Maritime &
Coastguard
Agency

Hornsea Project Four Offshore Wind Farm – EN010098

Examination Timetable – Deadline 2 – ExQ1 Response

**Figure 7.1 Illustrative SAR access lanes and HRA**

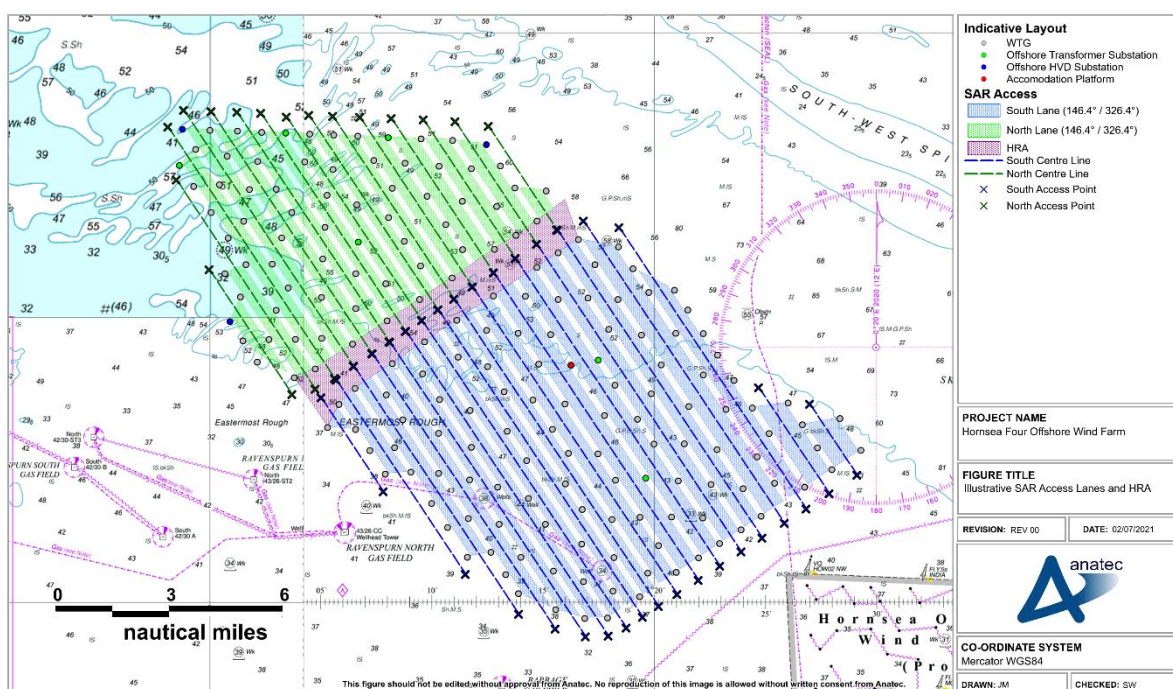
Safety Justifications for single line of orientation are accompanied by a proposed turbine layout design which is normally received post-consent. MCA has not received a proposed layout design and is unable to comment on the safety justification at this stage.

MCA is satisfied with the commitment to ensure the minimum width for SAR lanes is not compromised. This has been discussed with the applicant for agreement of the layout principles.
